April 14, 2004

RE: Stop work order, Hope Avenue- Lot 29
(CBL#390B029) (ID#2003-0260)

The City has received a second revised site plan in response to the January 28, 2004, and February 6, 2004 letters (non-compliance to the site plan).

MAXIMUM DRIVEWAY GRADES

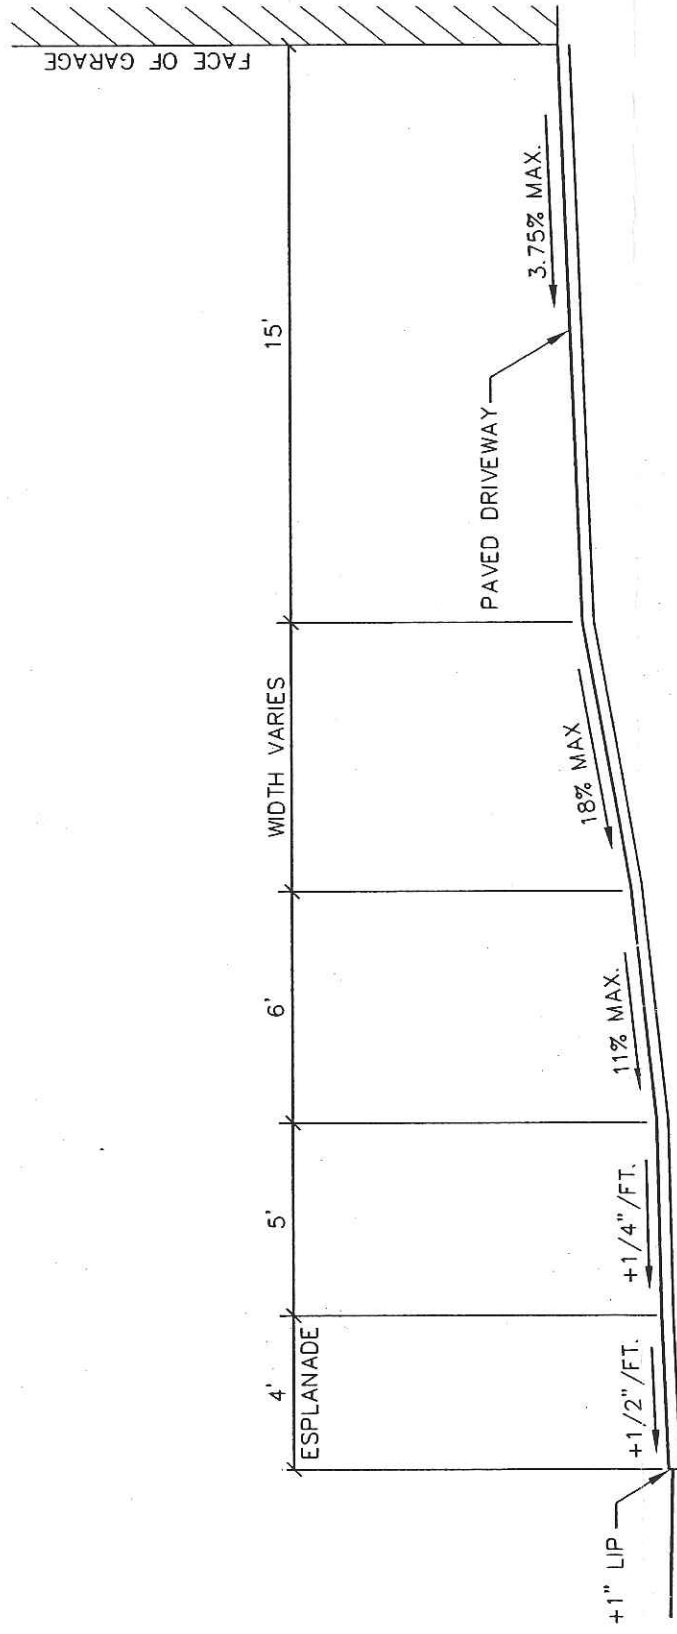
1. The driveway slope exceeds normal design standards. The proposed driveway slope is approximately 17%. To put this into perspective, the maximum slope for proposed City streets is 8%.
2. The potential impacts on lot 30:
 - a. Grading and drainage limitations.
 - b. Finish Floor Elevation: Lot 30's approved FFE is 87.0 on the approved subdivision. This appears unattainable at this time.
 - c. Driveway construction/slope may exceed normal design standards as a result of this proposal.

To resolve this situation we suggest that a house plan with grading be engineered for lot 30 demonstrating how it can be built in conjunction with lot 29. If the City and the owner of lot 30 agree on the house plan and it is recorded in the registry, that would resolve our concerns. With

Drawing Name: **Lot 29 Grading Plan**

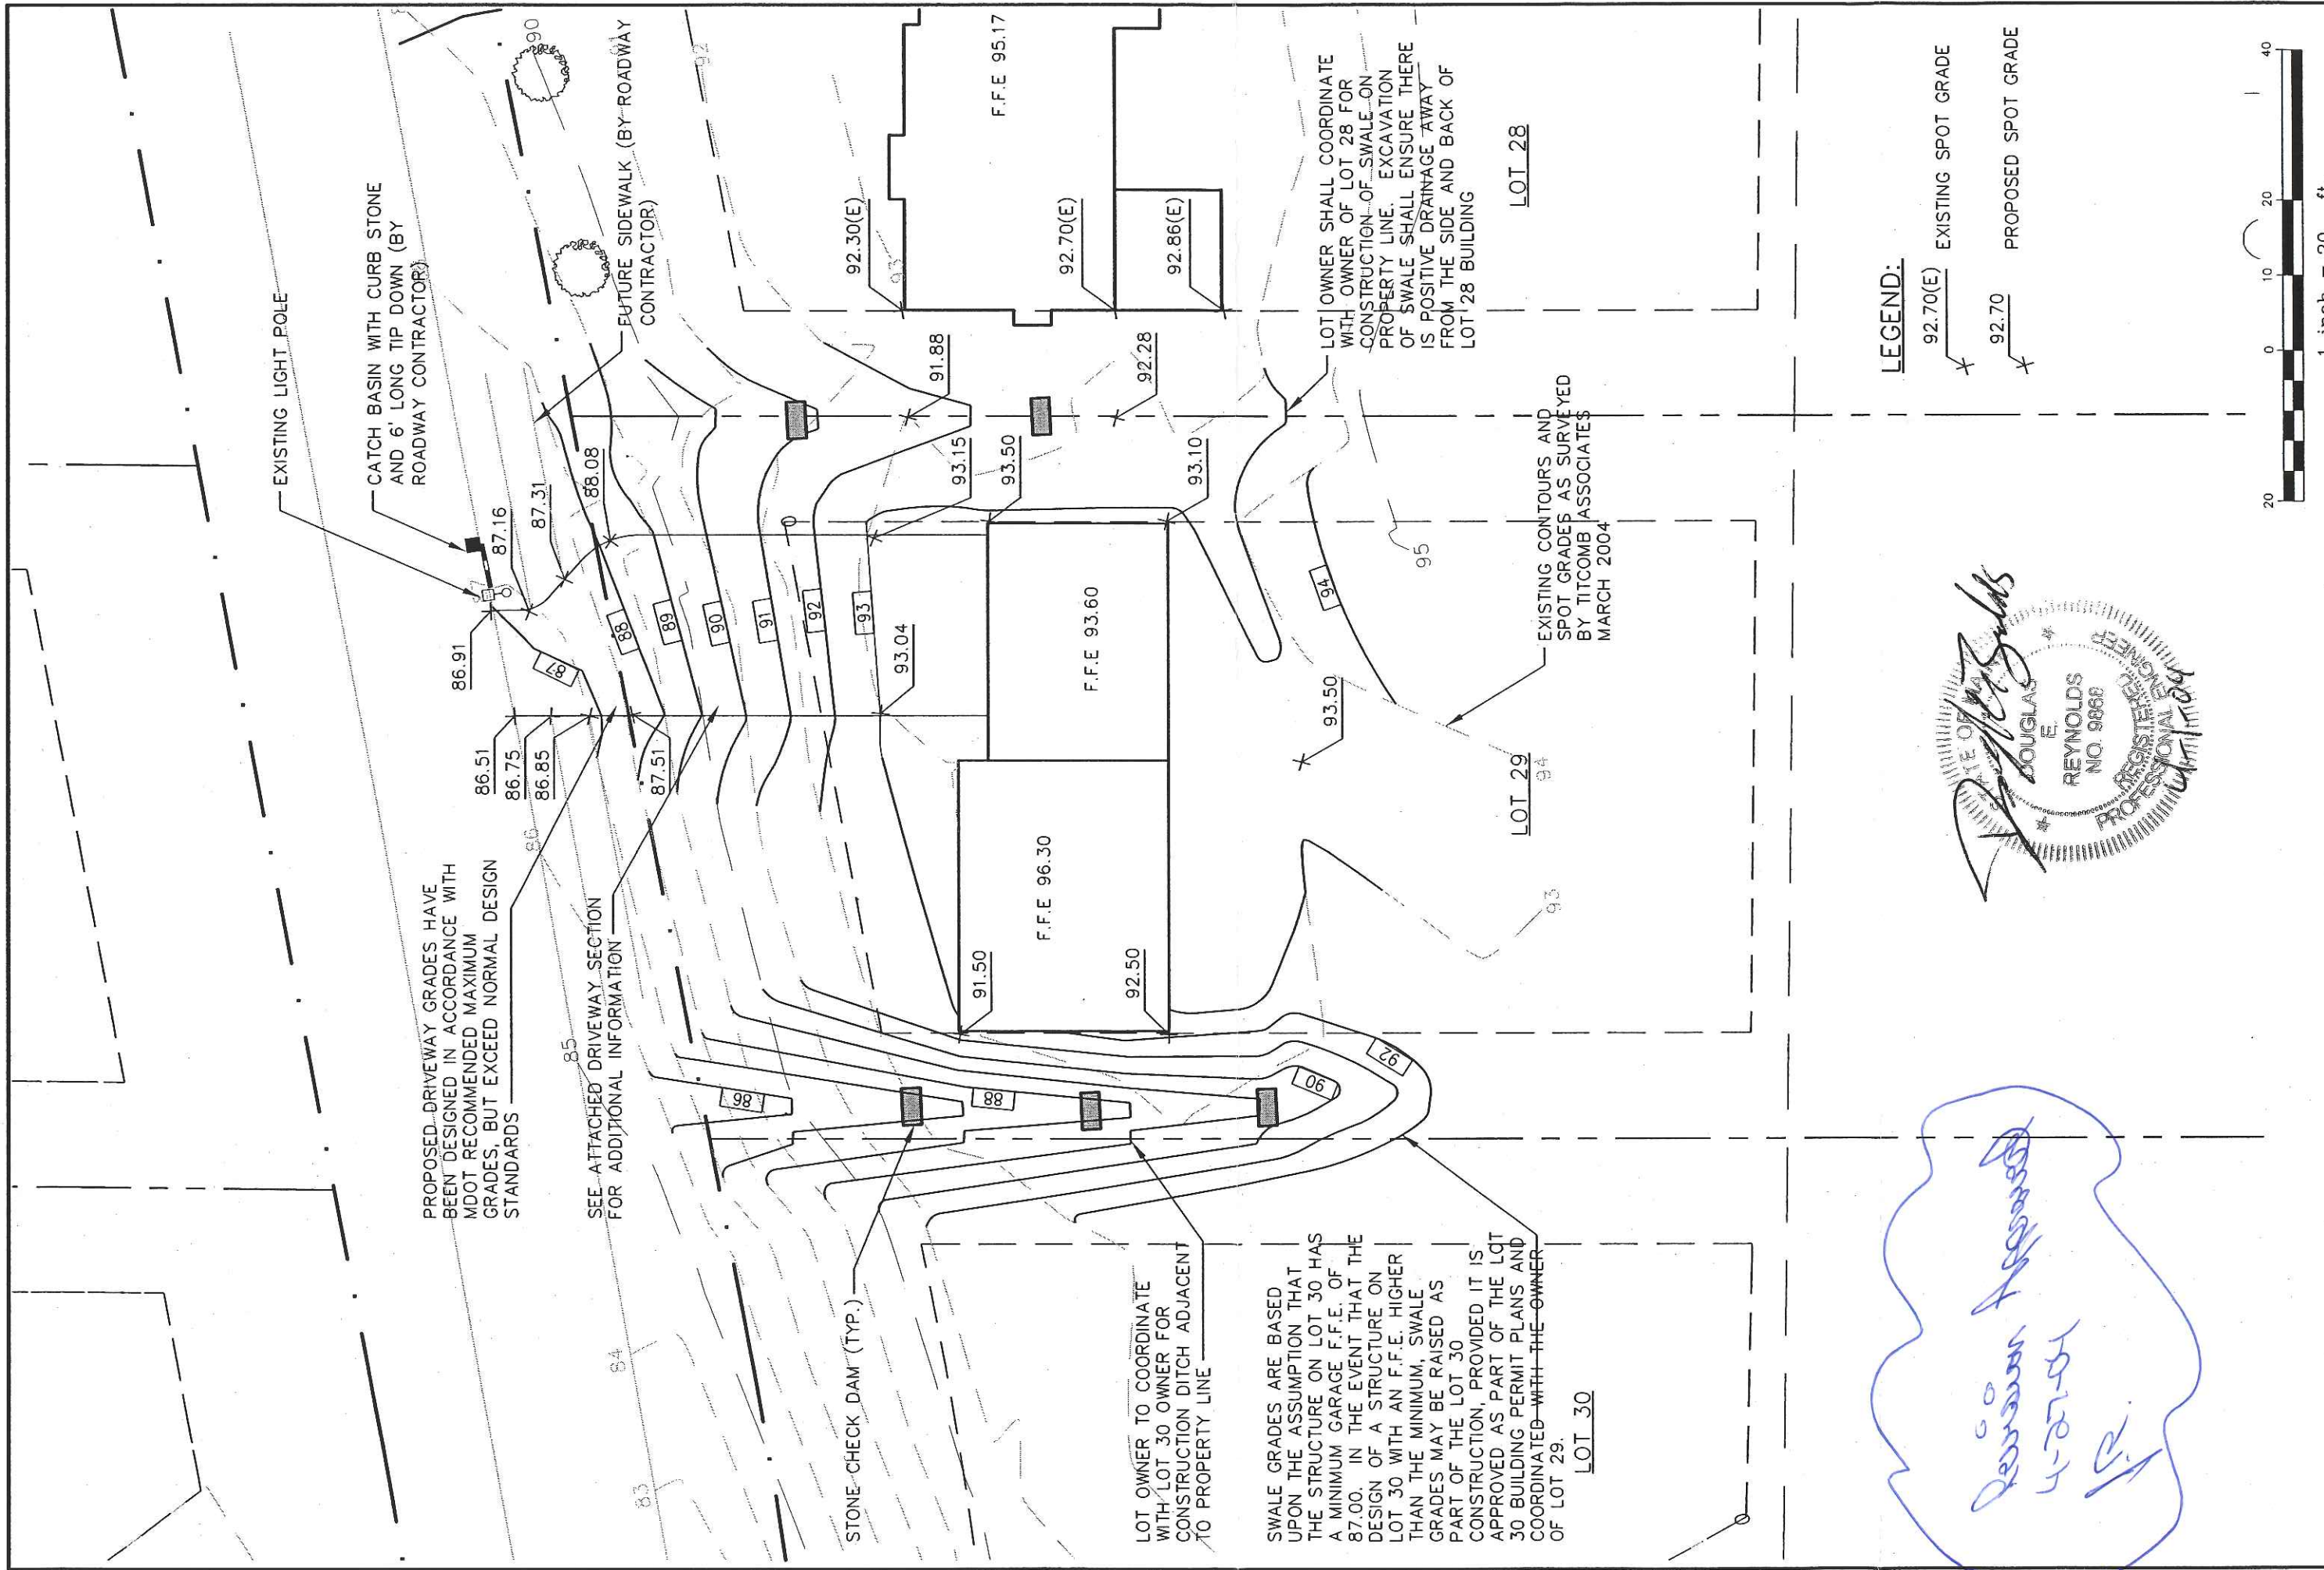
The submittal appears to address the drainage concerns between lots 28 and 29, however, the City cannot approve the submittals for the following reasons:

Lot 30 is one of the more restrictive lots, thus one of the more difficult lots to build in this subdivision. The addition of more restrictions due to the buildout of lot 29 only worsens the situation and 'passes' these issues along to the next lot.
